**Re: Arcadia Subdivision, Kanata: Stages 3 and 4**  
**Transportation Brief – Addendum #1**

This Addendum has been prepared to address the comments on the above-noted January 17, 2017 Transportation Brief received (July 5, 2017) from the City of Ottawa, along with the transportation-related implications of subsequent modifications to the Concept Plan.

Figure 2: Concept Plan

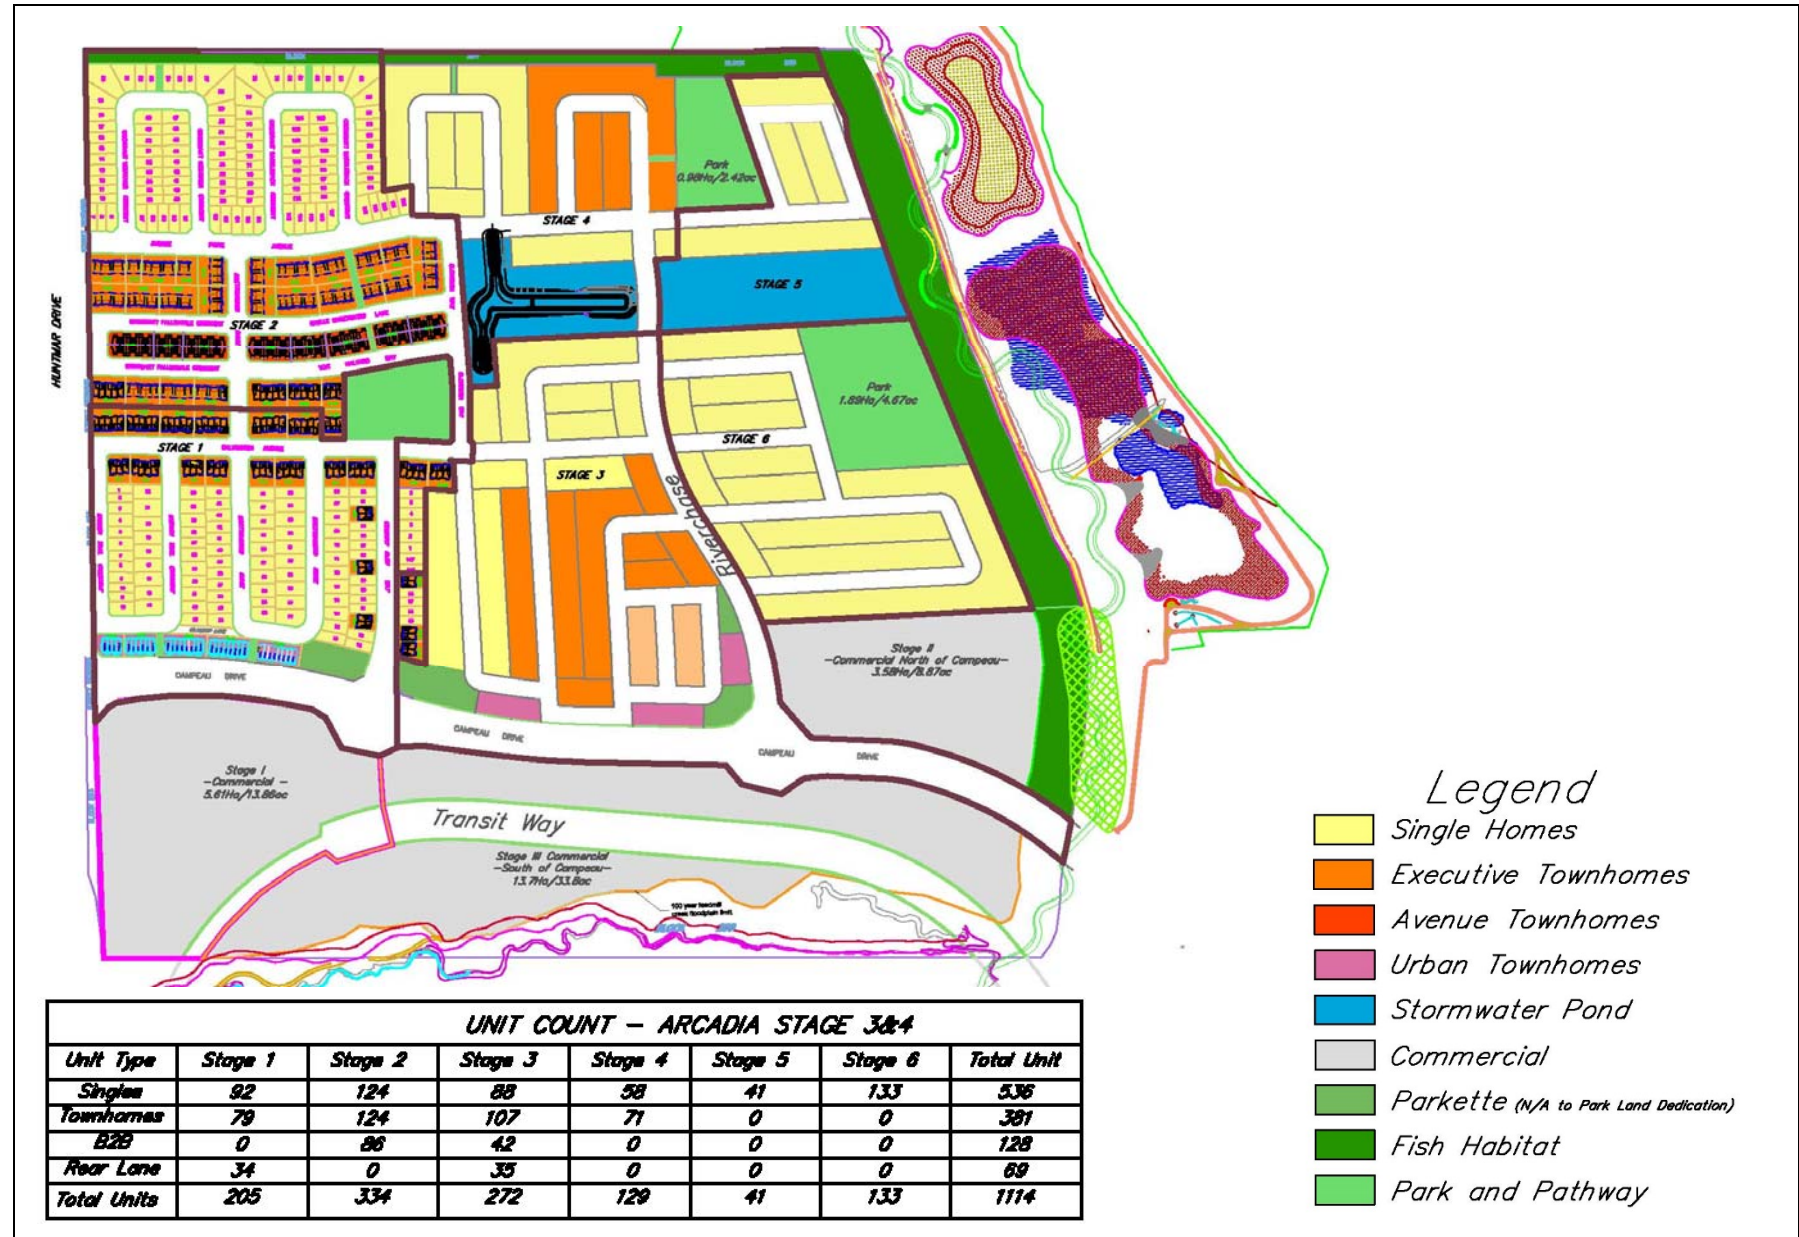
**Comment 14:** Consider street No. 8 intersects at street No. 2 (Riverchase) at 90 degrees. The opportunity to achieve this angle exists.

**Comment 15:** Riverchase and Paine Avenue are described as collector roads with 22m ROW and 8.5m pavement width. With future transit proposed on these roads, sidewalks are required on both sides. As well, both streets require cycling infrastructure. Please forward cross-sections of these streets for review to ensure all required infrastructures are accommodated as per the standards.

**Response 14:** The Concept Plan has been modified so that all local streets intersecting Riverchase, now do so at 90 degrees.

**Response 15:** As Paine Avenue is already 2/3 built as a 22 m ROW with sidewalks both sides and an 8.5 m paved surface, it was agreed with City staff at a May 2, 2018 meeting that this cross-section/ROW could be maintained on its extension east to Riverchase. With regard to Riverchase, a new submission was made to the City that included a 9.75 m paved surface, and a 3 m wide MUP on the east side, all within a 22 m ROW. A Deviation Report will be submitted to hopefully obtain approval for this cross-section and ROW. It is noteworthy that the proponent is now also considering a mini roundabout at the Paine/Riverside intersection, and either a roundabout or pedestrian crossover at the Calvington/Riverside intersection. The proposed roundabout at Riverchase/Paine would integrate the MUP on the east side of Riverchase with the shared lane cycling on Paine.
